Sydney Metro City & Southwest Chatswood to Sydenham Environmental Impact Statement Objection

This objection relates to the EIS SSI 7400 (Sydney Metro City & Southwest Chatswood to Sydenham).

Figure 4-1 Preliminary station location options

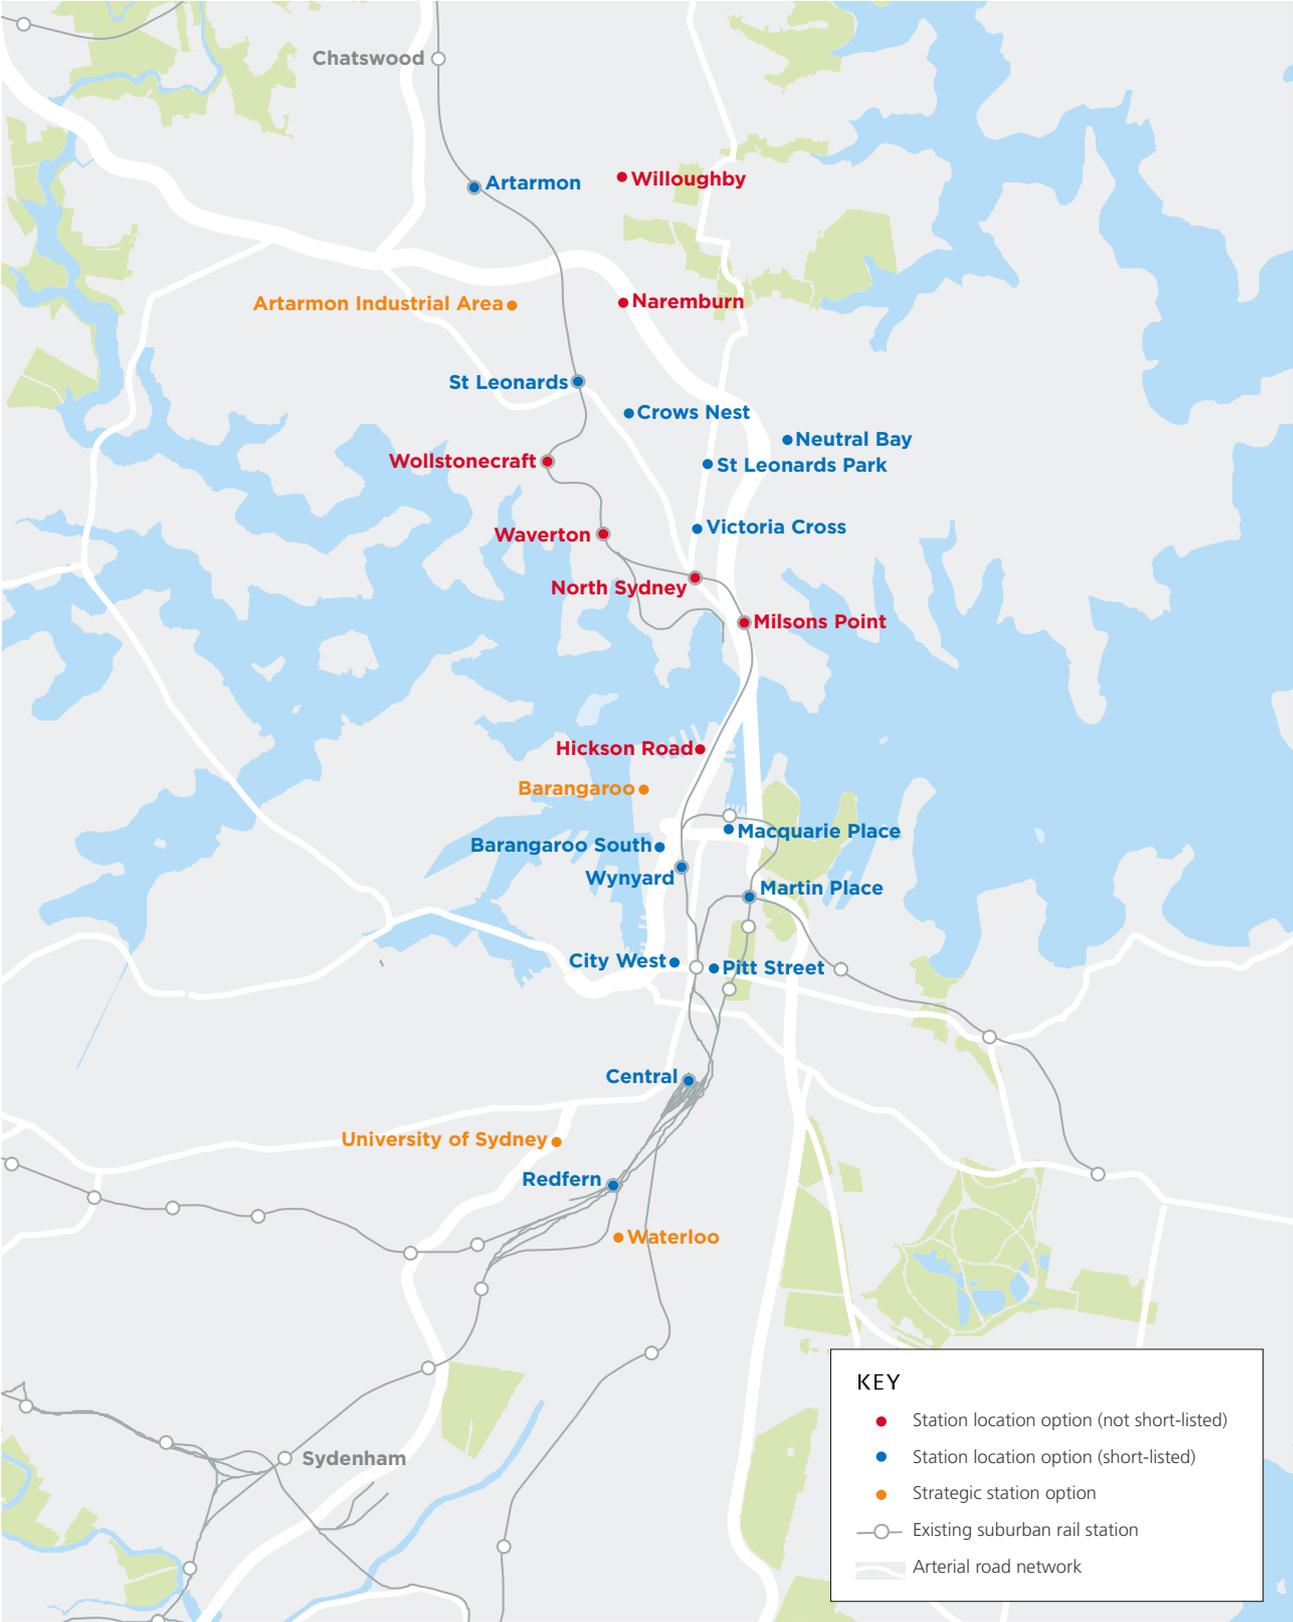
The Phase 1 station location phase failed to identify a viable Alexandria station at the approximate 'mid-point' of the Waterloo alignment (see Figure 1). This submission proposes and evidences why the provision of an additional station (Alexandria) is a minimal response to better provisioned and better integrated transport systems in the inner-city.

Figure 2: Phase 1 did not identify viable station located on the 'mid-point' of the Waterloo - Sydenham alignment

Figure 4-6 Performance of station options between Central and Sydenham against the project objectives

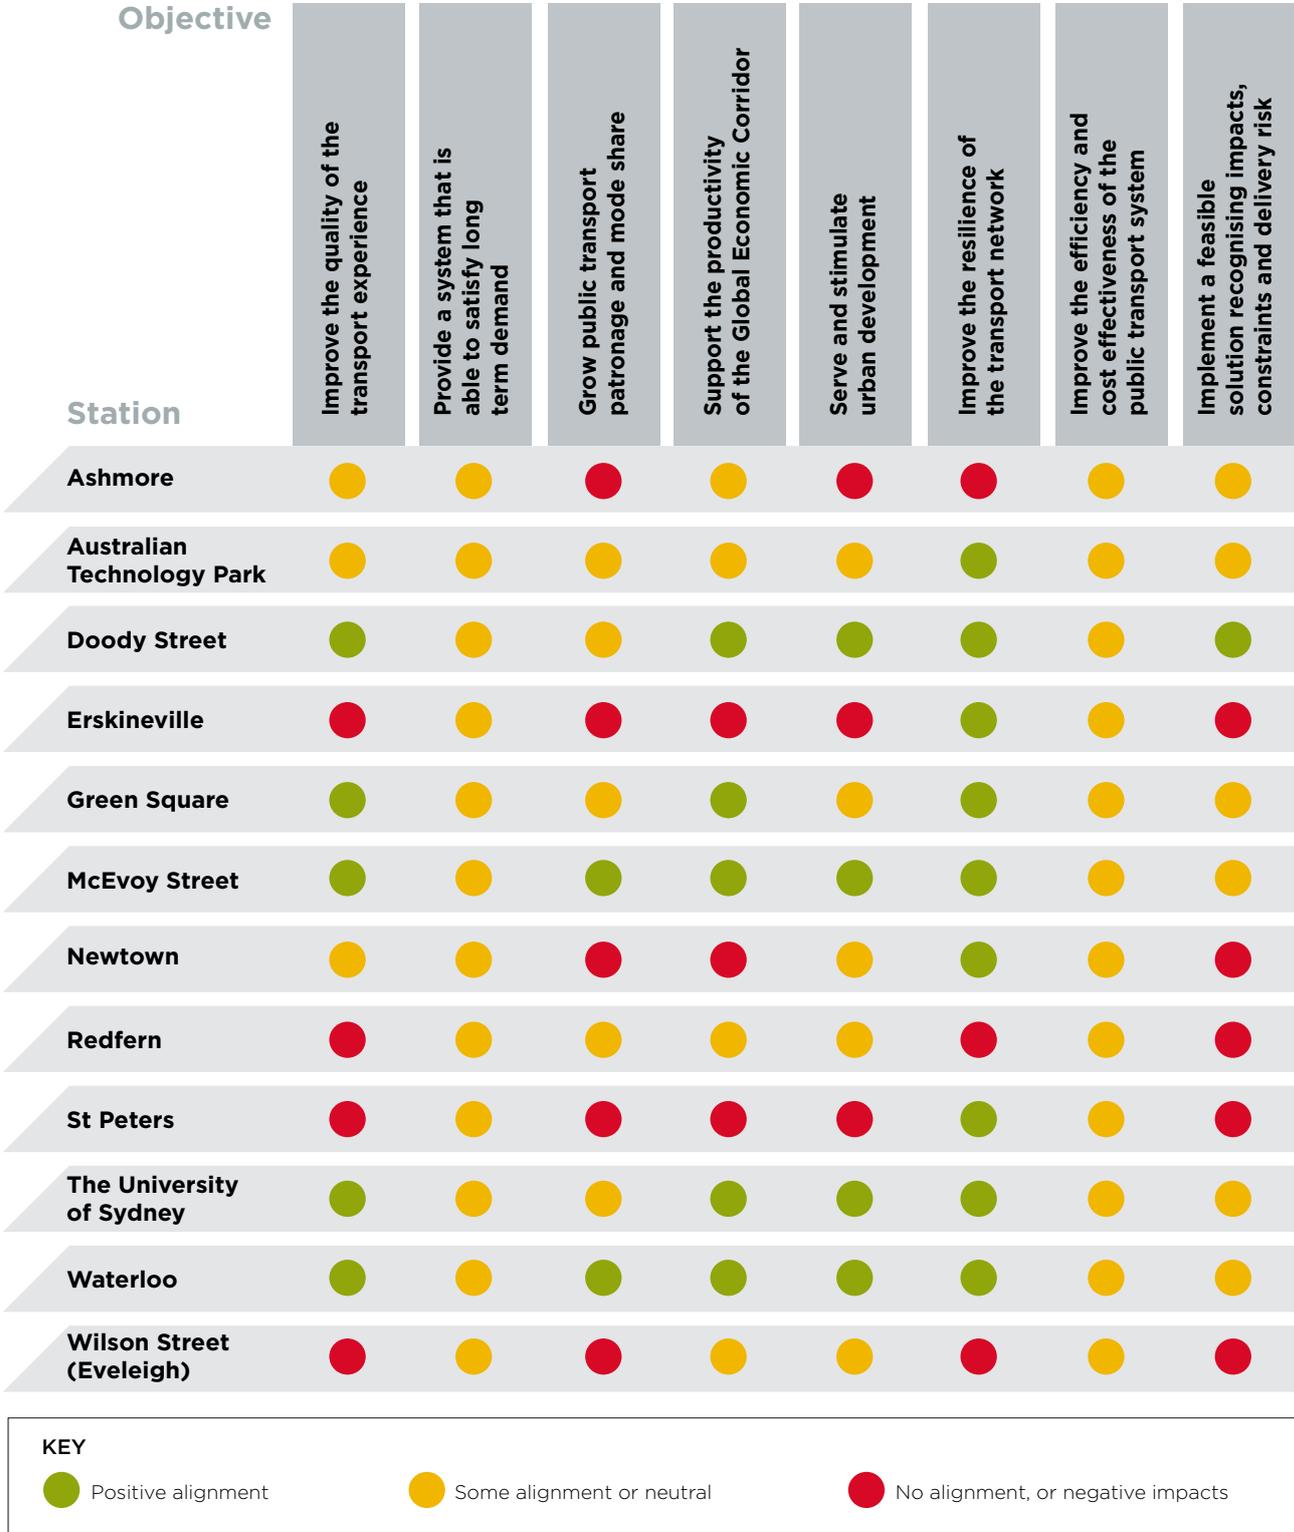
The proposed Alexandria station location is within a few hundred meters of the positively evaluated McEvoy street station location and therefore shares many of the same positive attributes already identified through the Metro projects own initial planning process (See Figure 6).

The location offers the same urban activation profile as was modelled previously for the McEvoy station location. Figures below represent the current and the proposed (revised) Project Objectives matrix for Alexandria Metro station and brief notes follow on each criteria.

Figure 4-7 More recent alignment options considered based on possible station location combinations

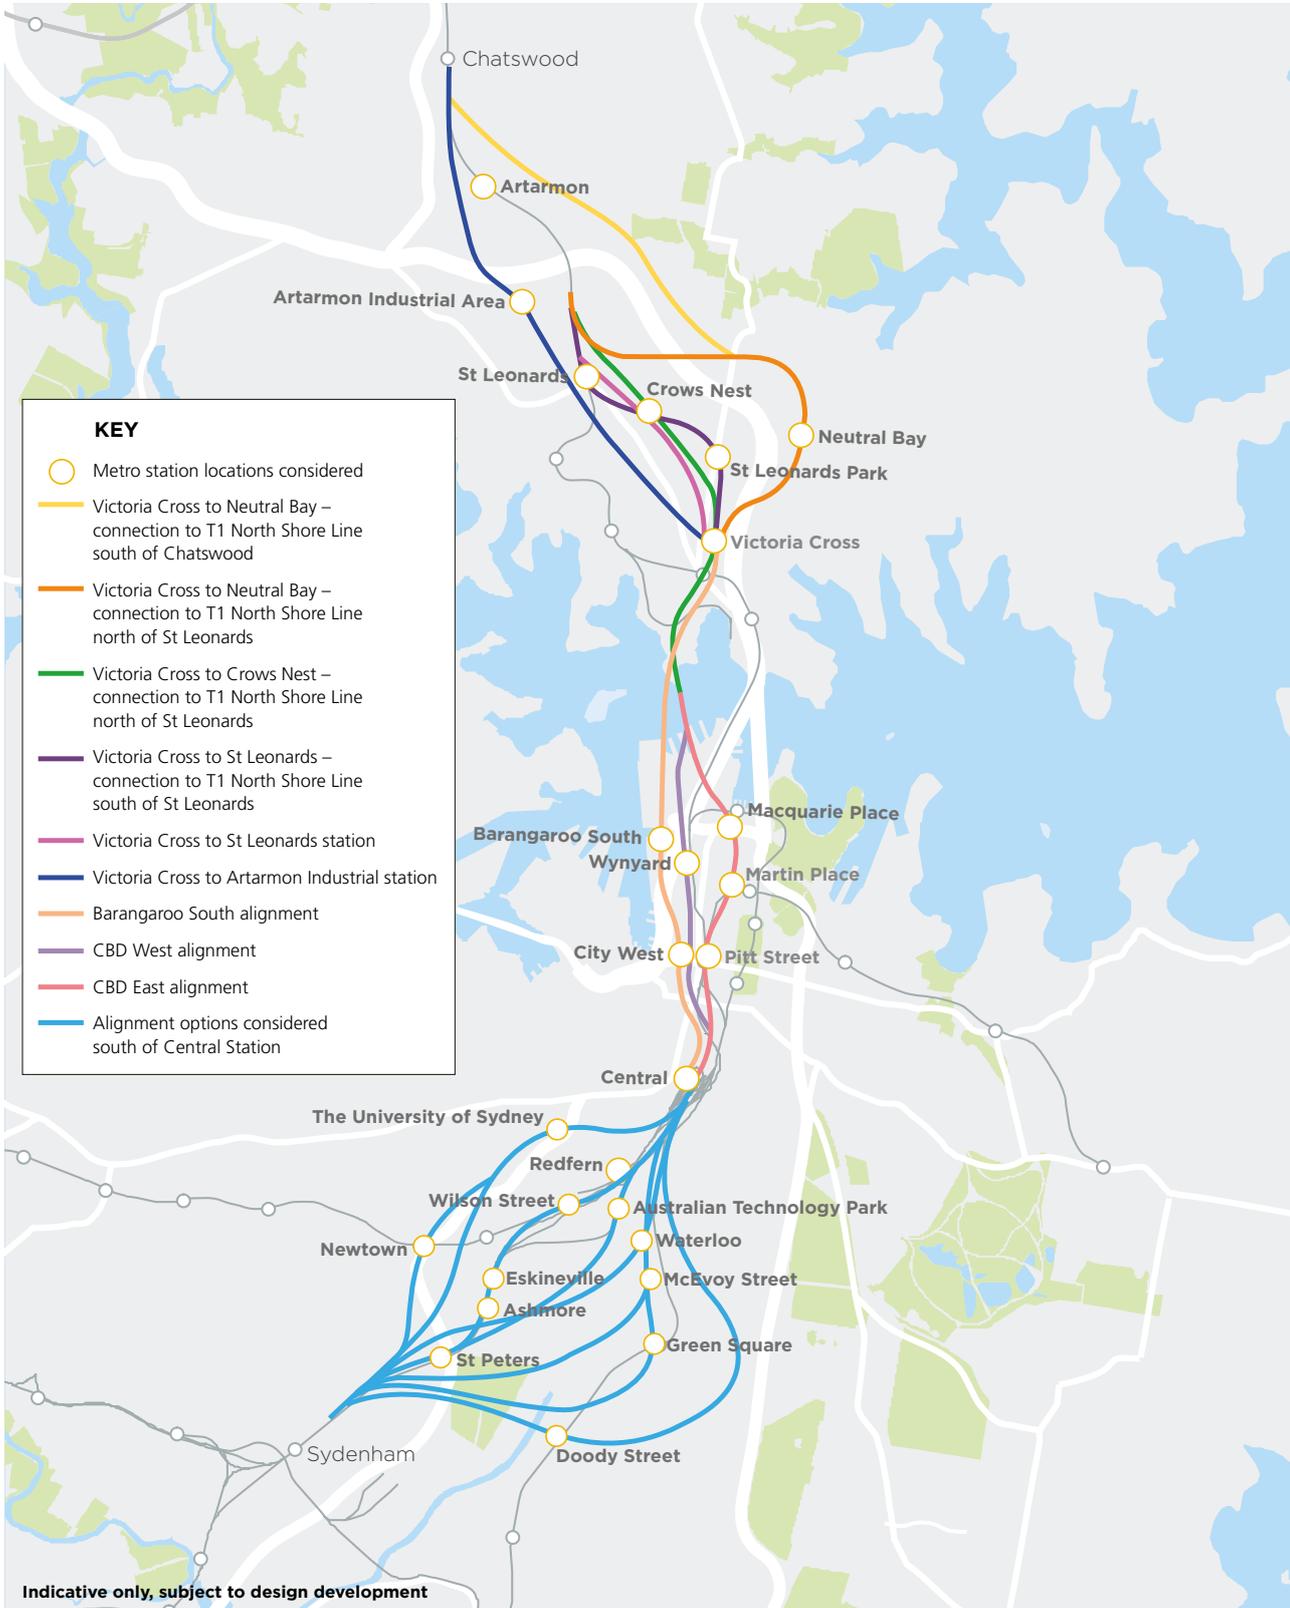
Note: This station location is NOT the same as the determinations made on an Ashmore station location, which was situated closer to Erskineville station. It therefore cannot be judged on the outcomes of the Ashmore station performance. In addition, this station location was NOT evaluated on the Metro Alignment Options (See Figures 2 and 3).
